August 29, 2022

County File: ANX2214

Re: Villages at Waterview North Addition No. 1 Annexation Petition

ANNEXATION PLAT

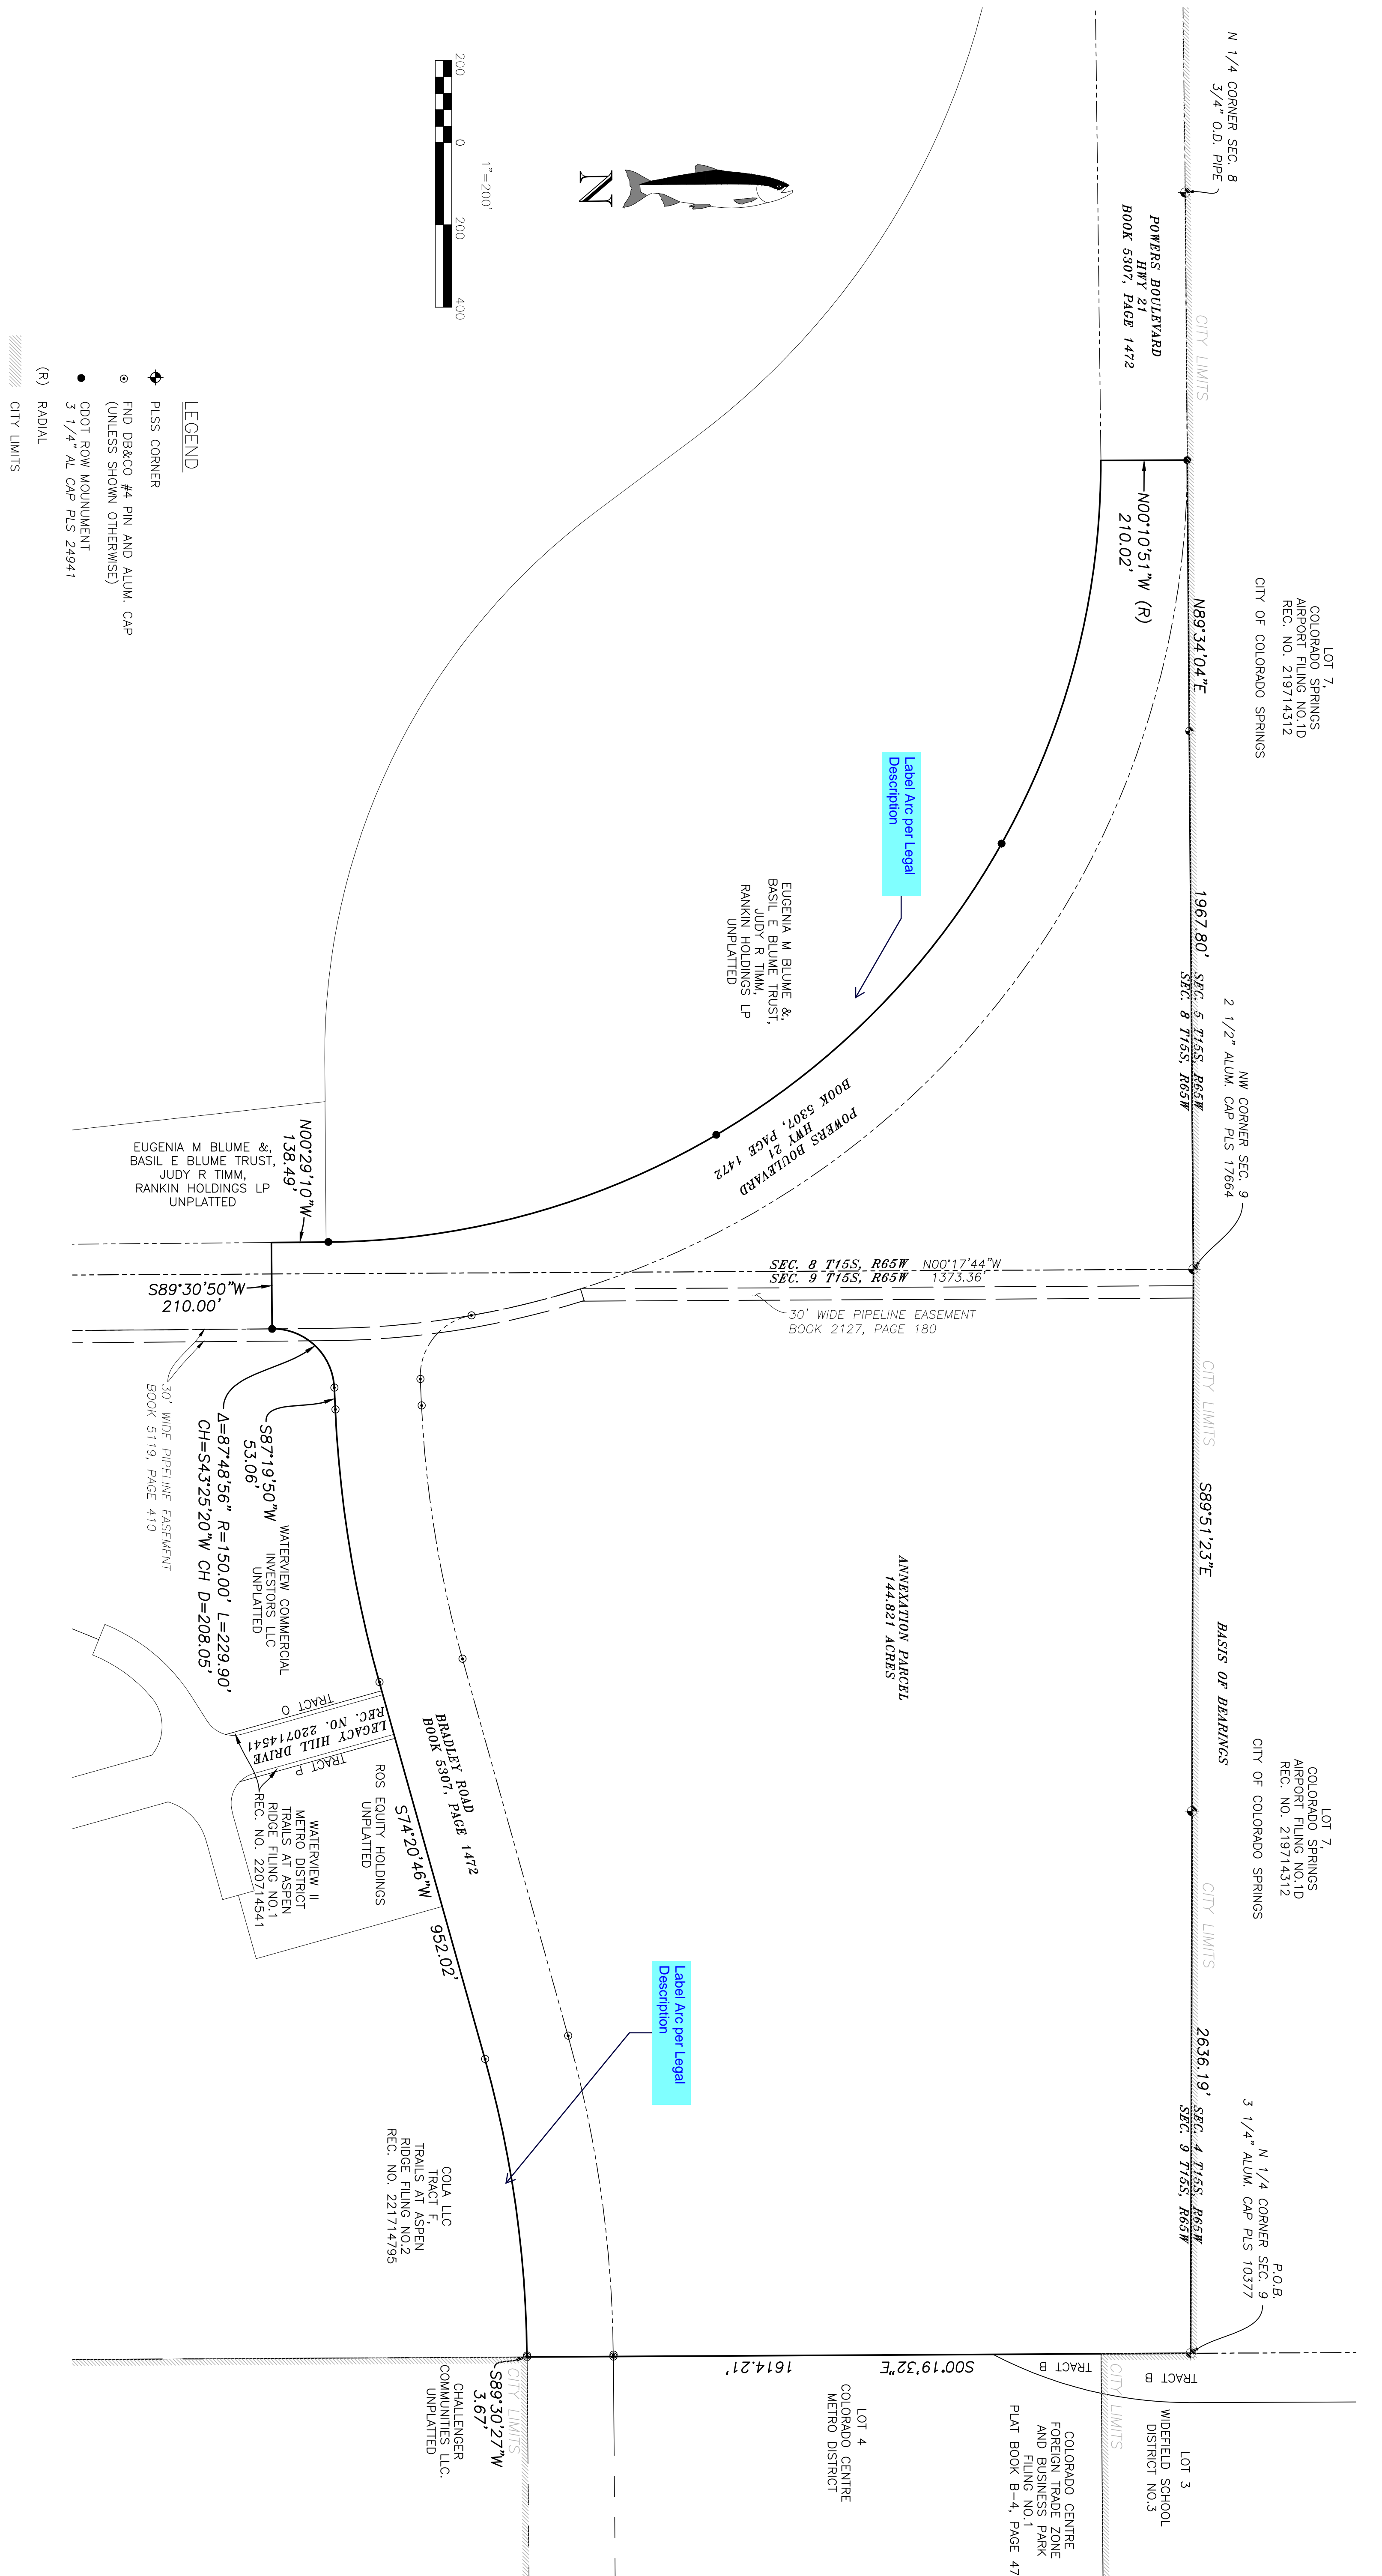
See redline comments on the attached annexation plat map.

- Label the Arc at the southeast corner and the western side of the annexation boundary.
